Document MCO 1.6

Updates to Application Documentation

The East Midlands Gateway Phase 2
and Highway Order 202X and The East Midlands Gateway
Rail Freight and Highway (Amendment) Order 202X

Section 51 advice for applicant relating to documentation as to submission dated August 2025

number
FIGURE 3a rev
-

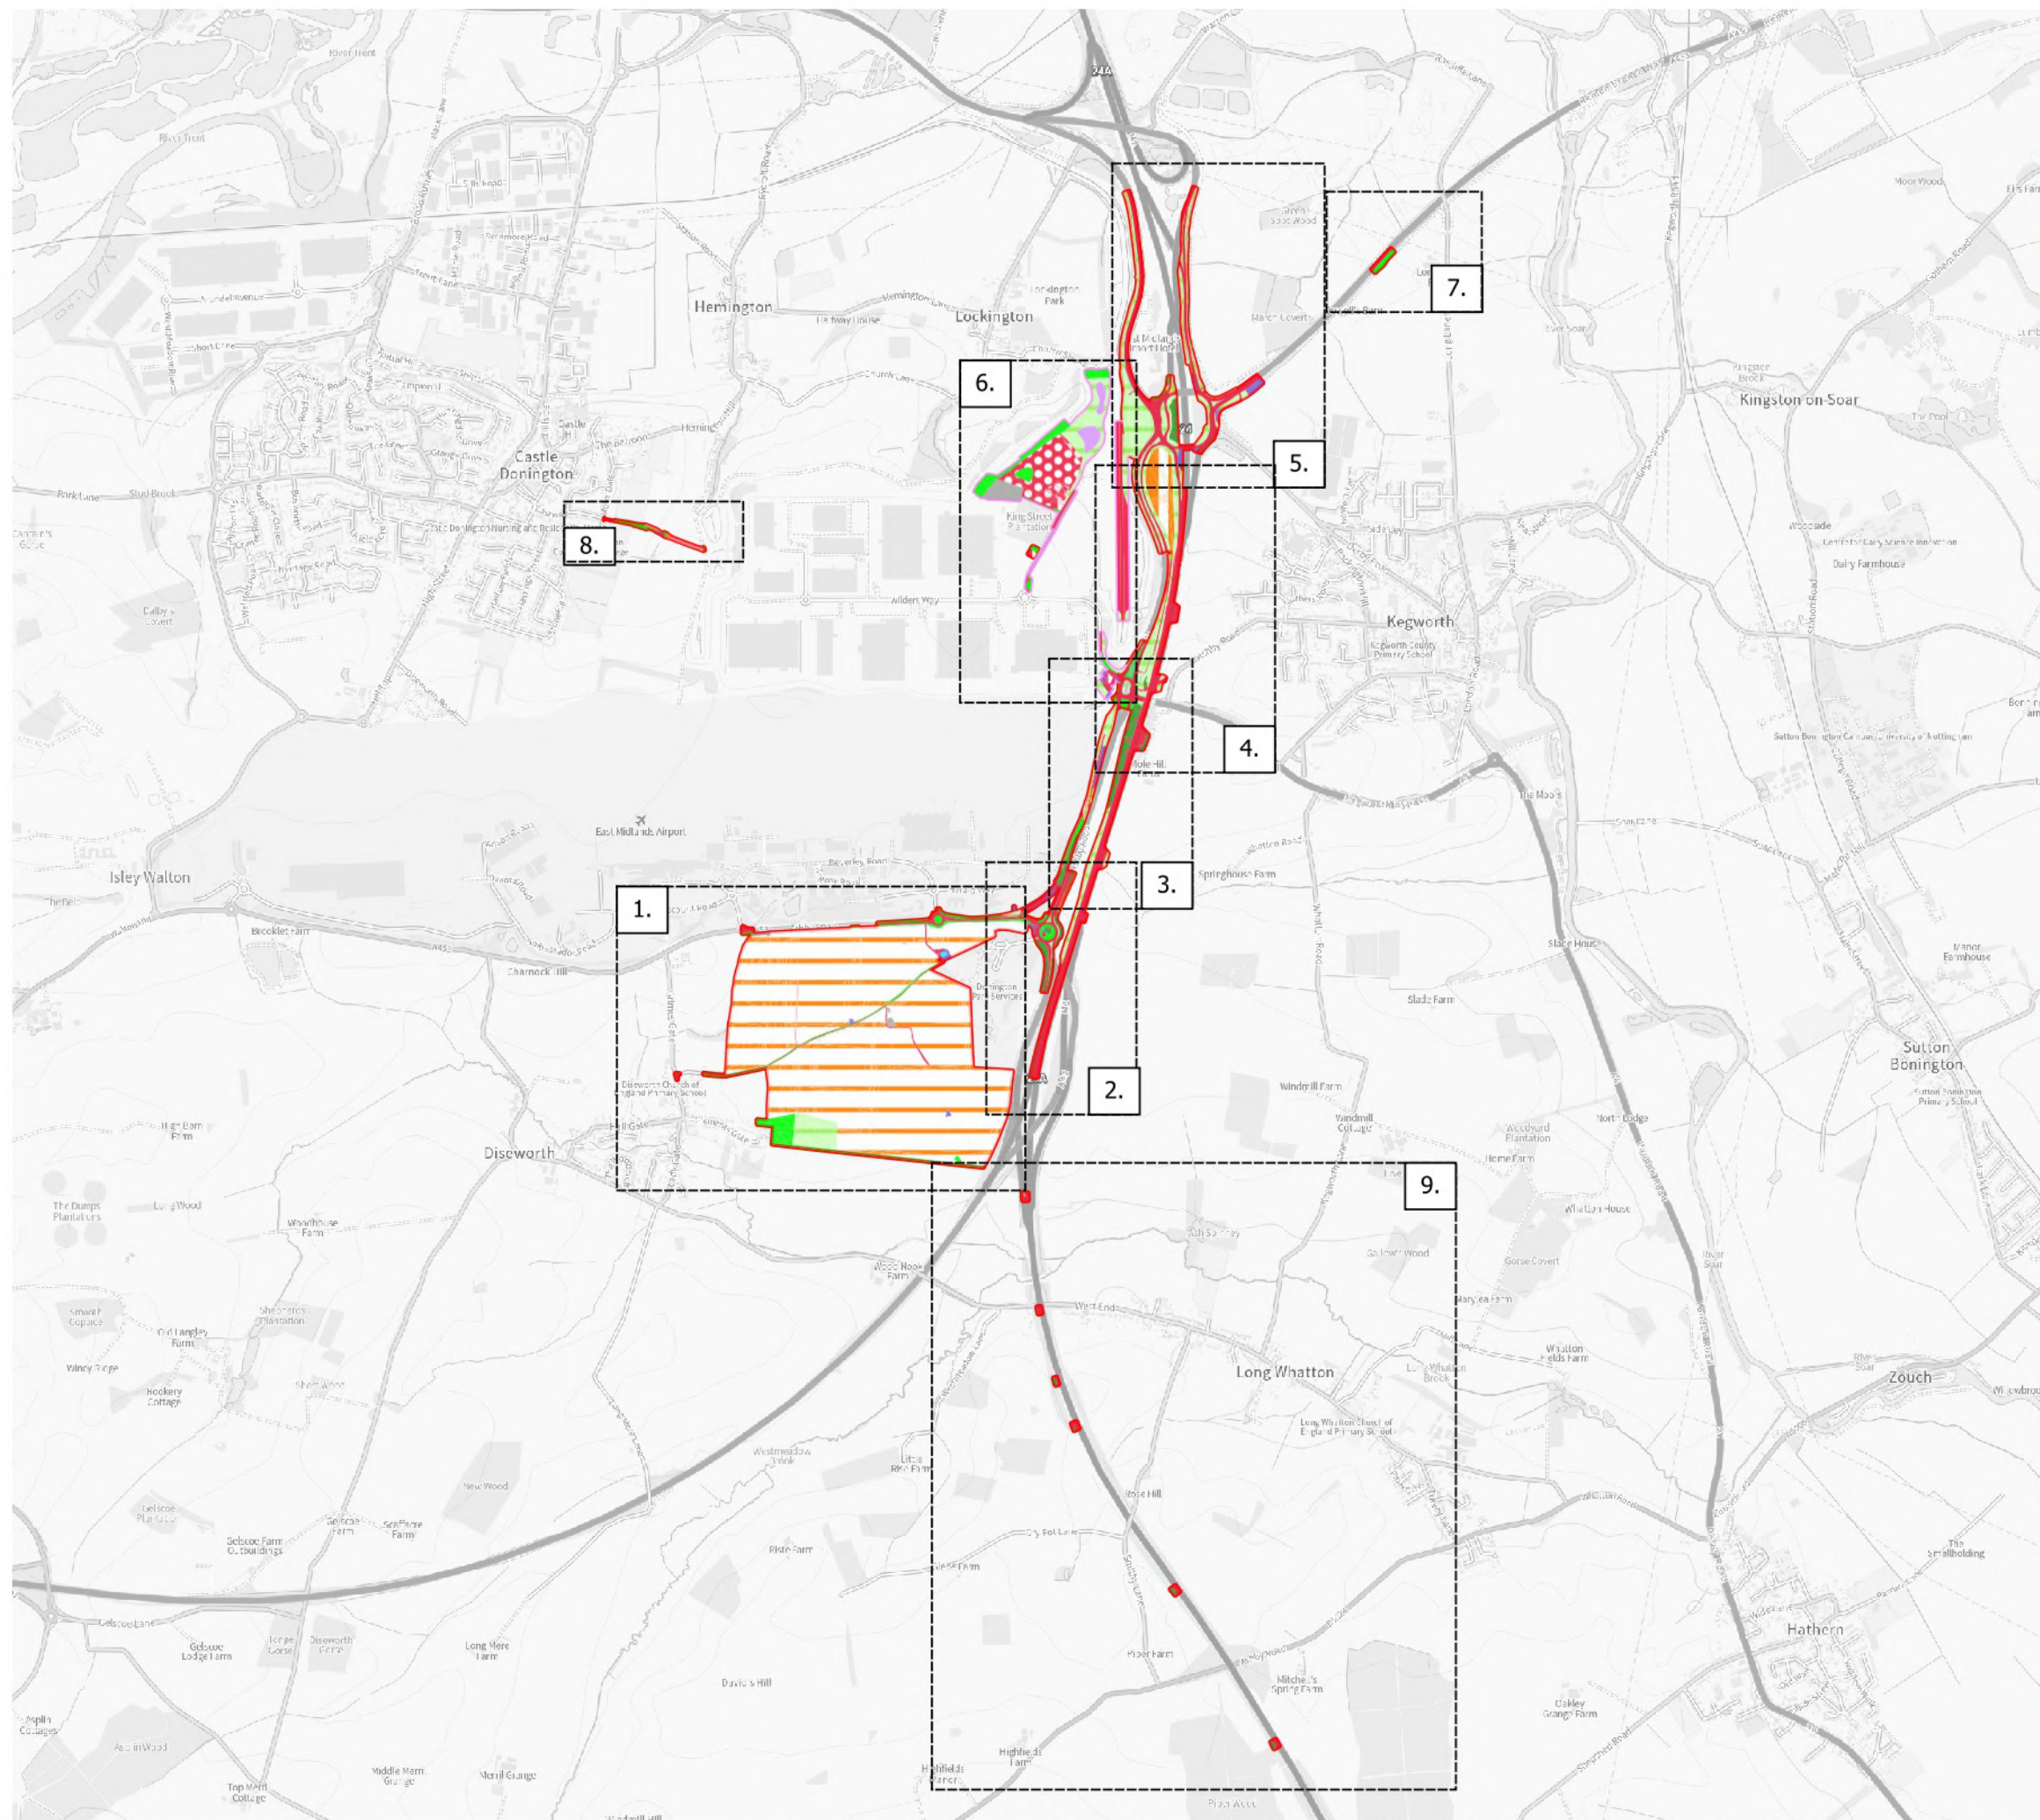
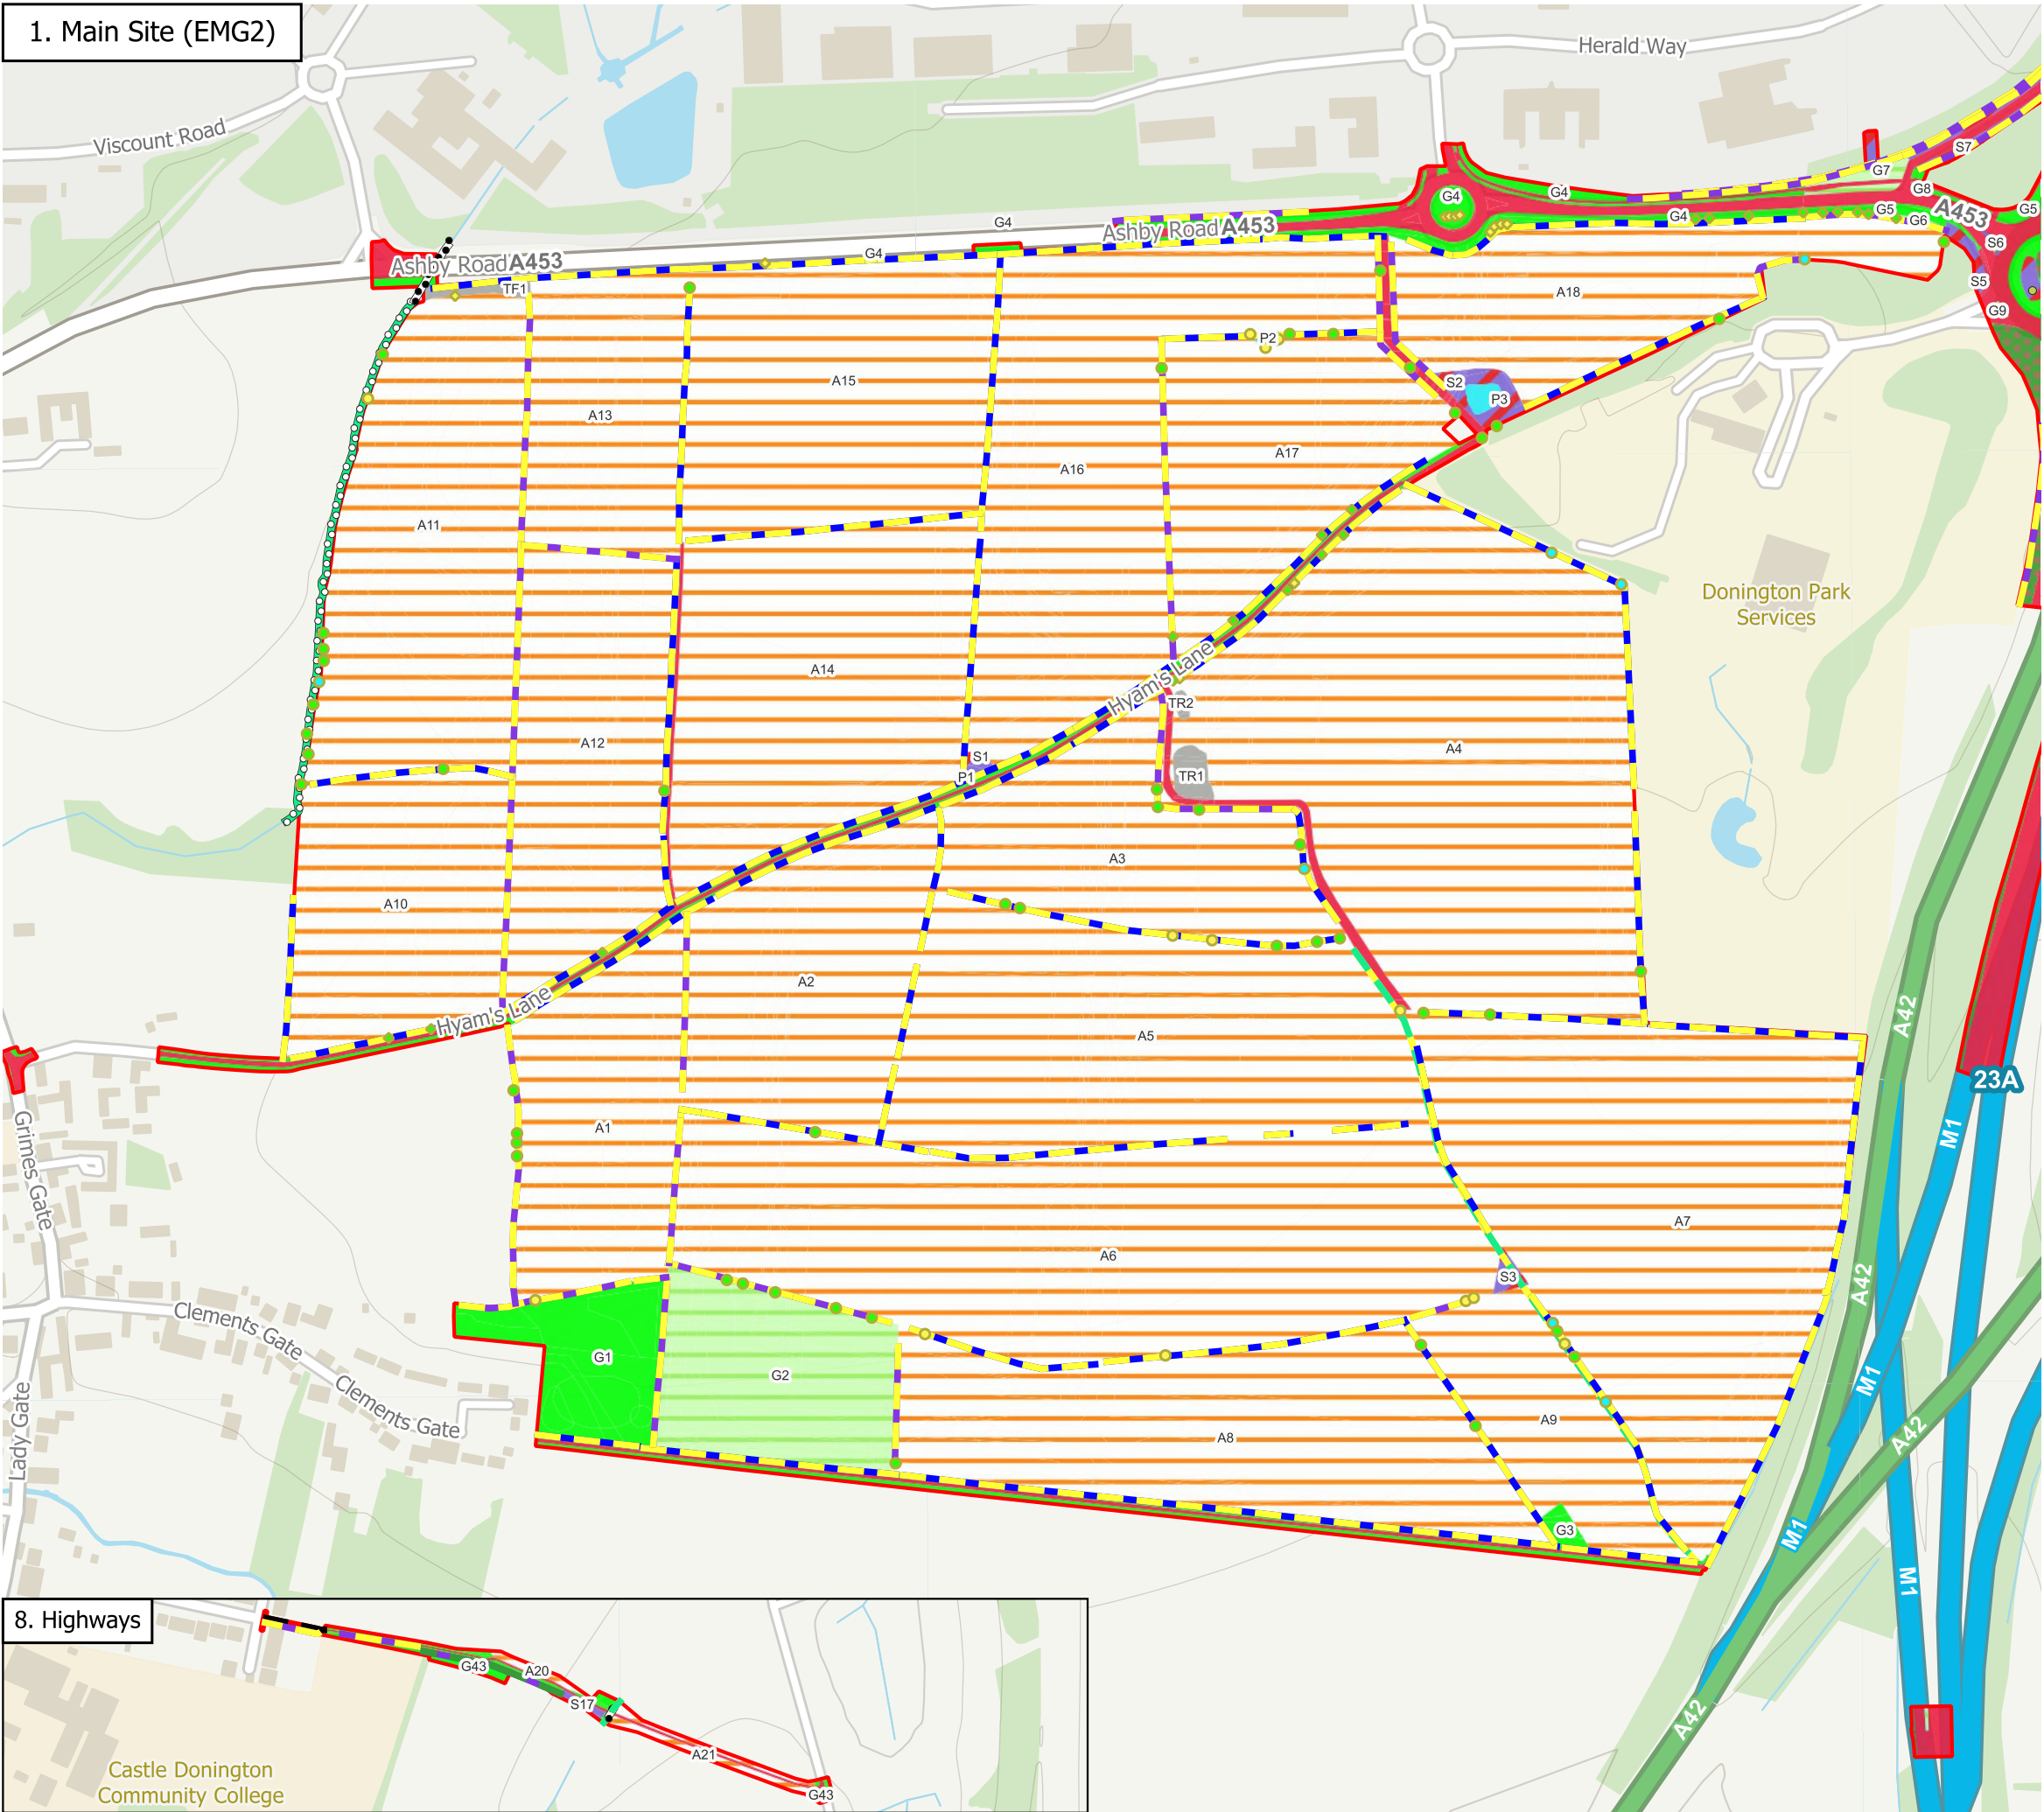
32.	<p>The following reports contain figures that are difficult to read (inappropriate scales, black and white/ indistinct mapping backgrounds):</p> <ul style="list-style-type: none"> • ES appendix 6.9A: Preliminary Ecological Appraisal • ES appendix 6.9D: Bird Report • ES appendix 6.9G: Reptile Report • ES appendix 6.8D: Modelled Ecological Receptor Locations 	Figures and maps used within the ES, particularly where these are embedded within text, should be reviewed for clarity and ease of understanding.
